6 November 2007

Re: Response to comments from Department of Planning, Department of Primary Industries and Department of Environment, Conservation and Climate Change.

The purpose of this letter is to respond to, and provide clarification for, a number of questions and comments provided by the Department of Planning and other relevant State agencies.

Stormwater Management

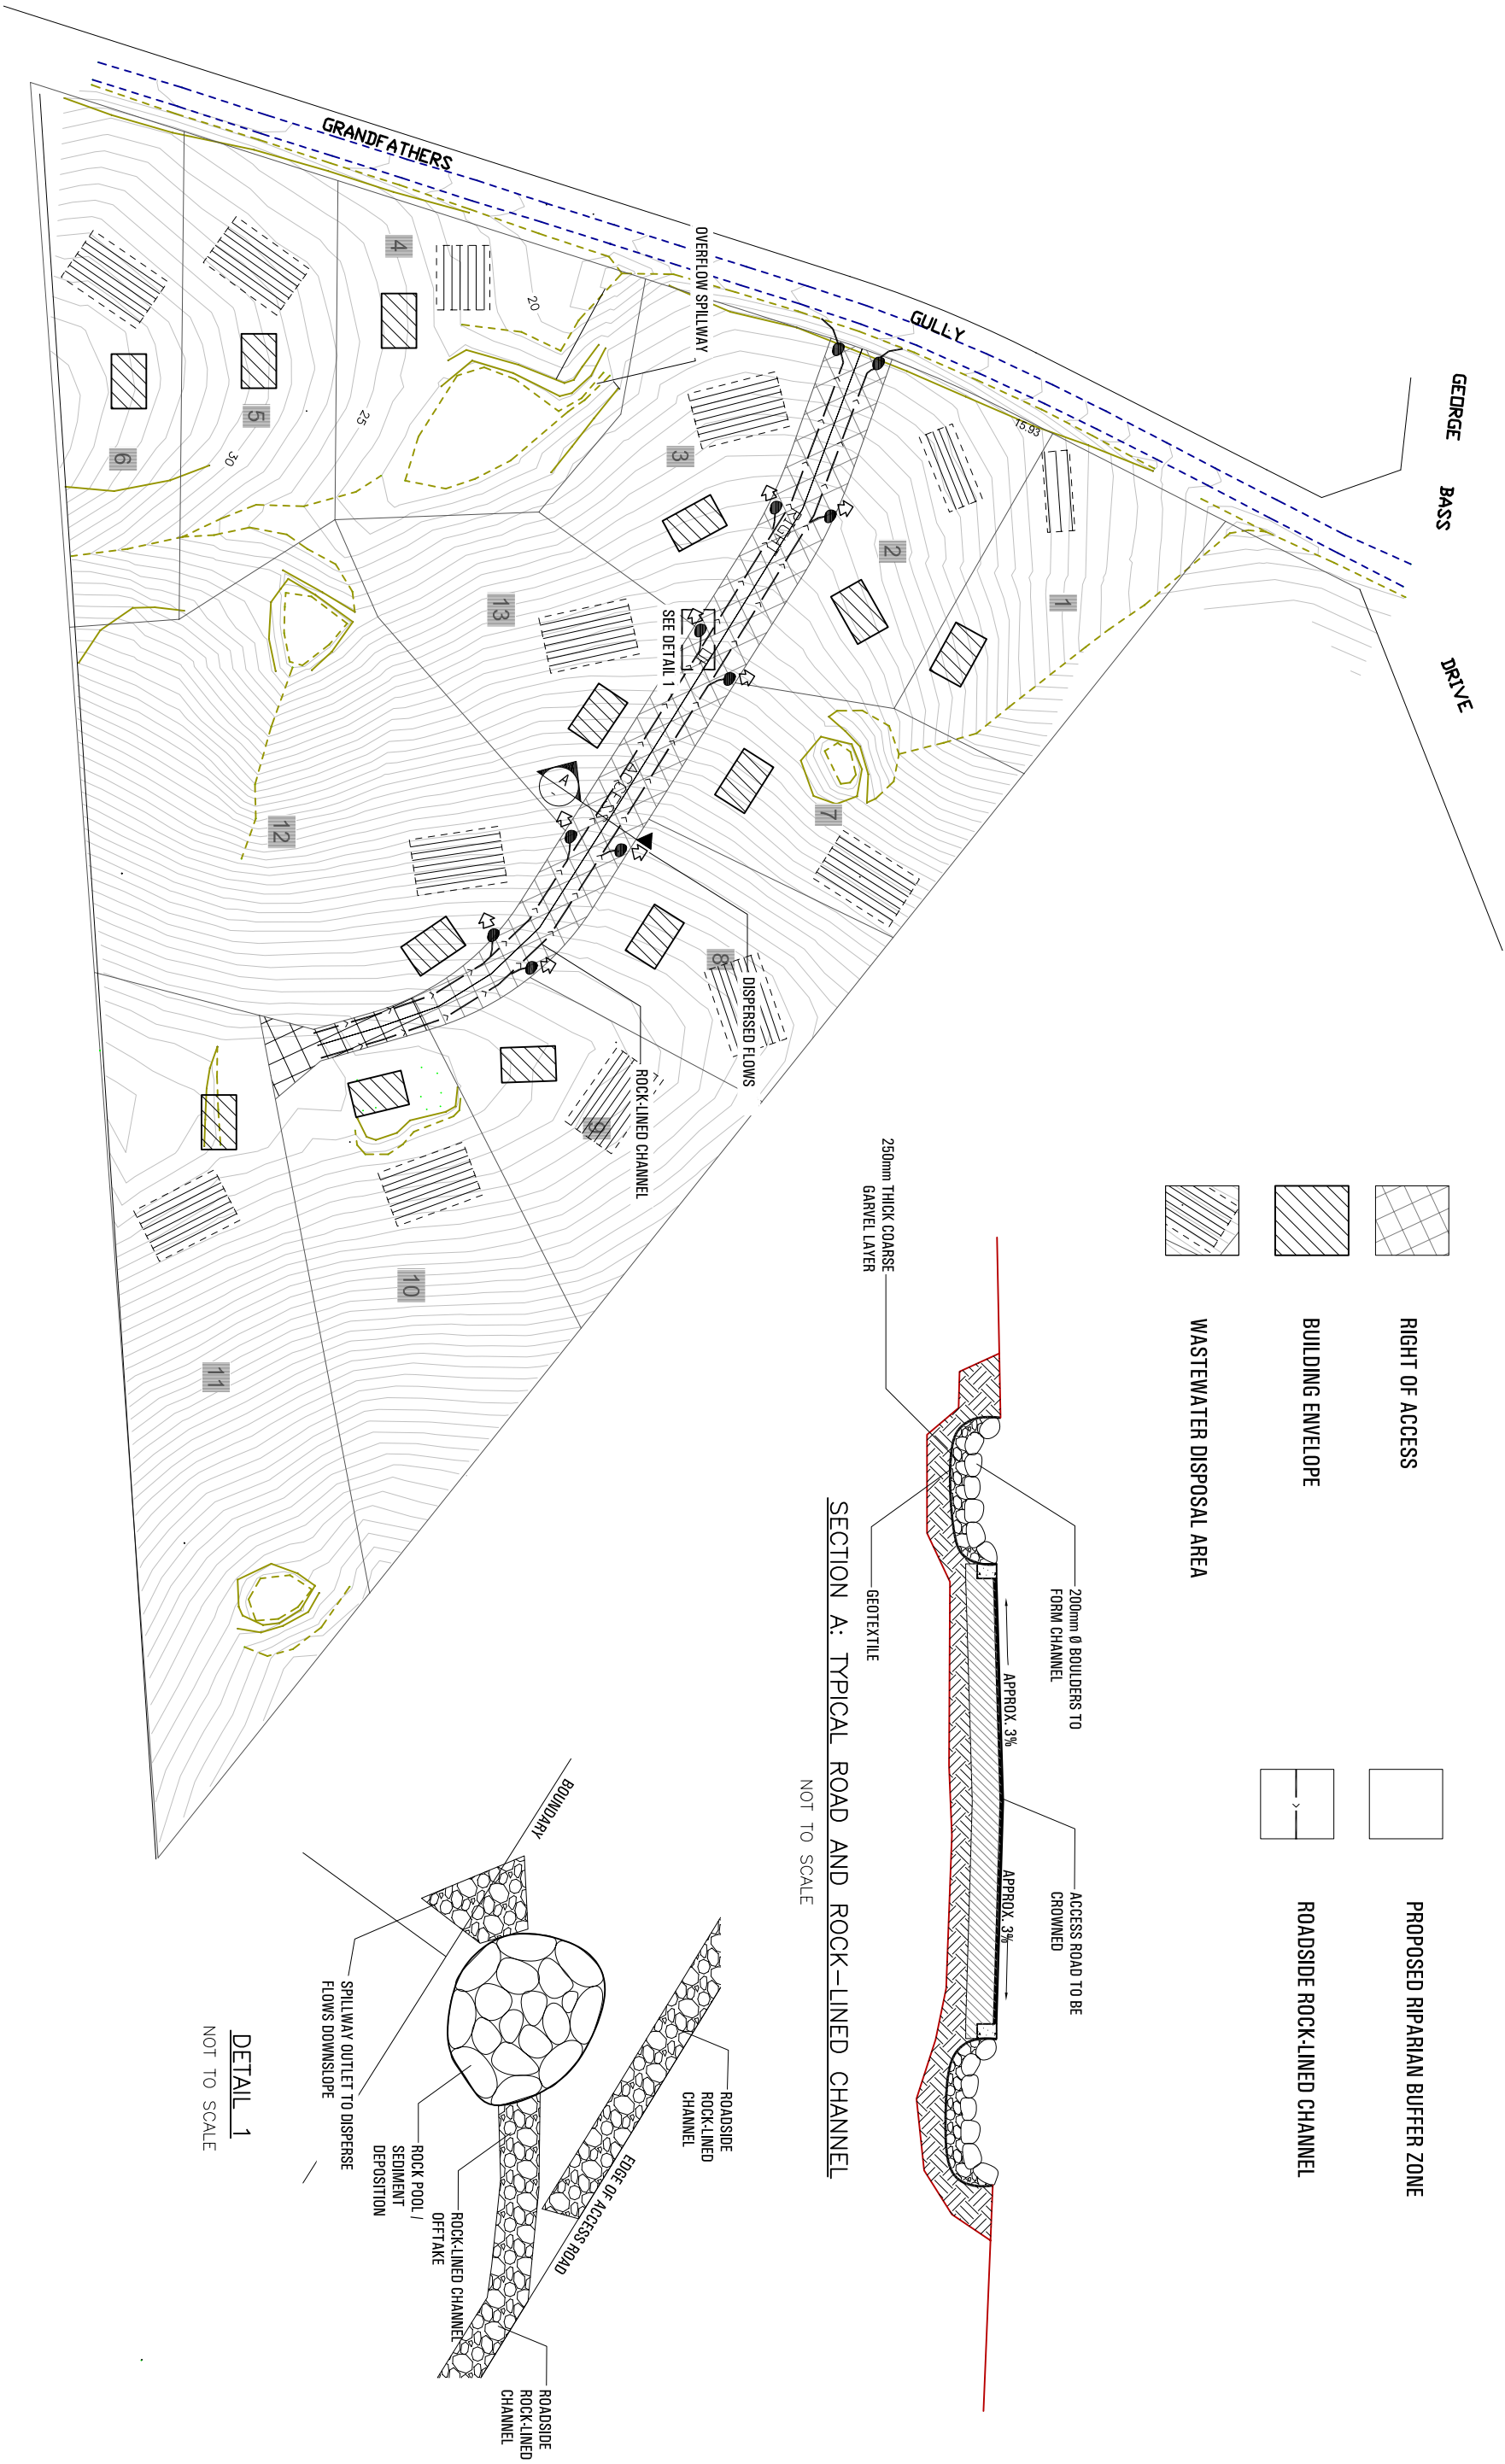
Stormwater	<ul style="list-style-type: none"> Roadway ponds and spillways should be treated in a similar manner to “turn out” drains in other rural residential areas. A level spreader should be provided at the pond spillway to produce diffuse flow. Individual DAs for housing on each lot will be required to meet Council’s requirements for stormwater management from access roads and tank overflows. Stormwater is to be diverted around wastewater disposal areas. Individual DAs for new houses will require detailed wastewater designs to demonstrate this. Weed seed, “garden escapes” fertiliser and herbicide management are best addressed through behavioural change. A significant buffer (generally greater than 50m) exists between building envelopes and receiving waters providing a level of protection.
On-site Wastewater management	<ul style="list-style-type: none"> The on-site wastewater disposal areas are sized based on a monthly water balance to account for wet periods. Wastewater disposal is undertaken below the soil surface to isolate as much as feasible treated effluent from surface stormwater flows. The treatment systems and disposal areas have been designed to protect downstream ecosystems in accordance with AS 1547:2000, the Environment and Health Protection guidelines for On-site Sewage Management (Department of Local Government, 1998) and Councils On-site Sewage management Code of Practice. All the recommended health and environmental buffers have been allowed for. Maintenance contracts between home owners and the provider of the wastewater treatment system will need to be provided for as part of individual DAs for each lot.
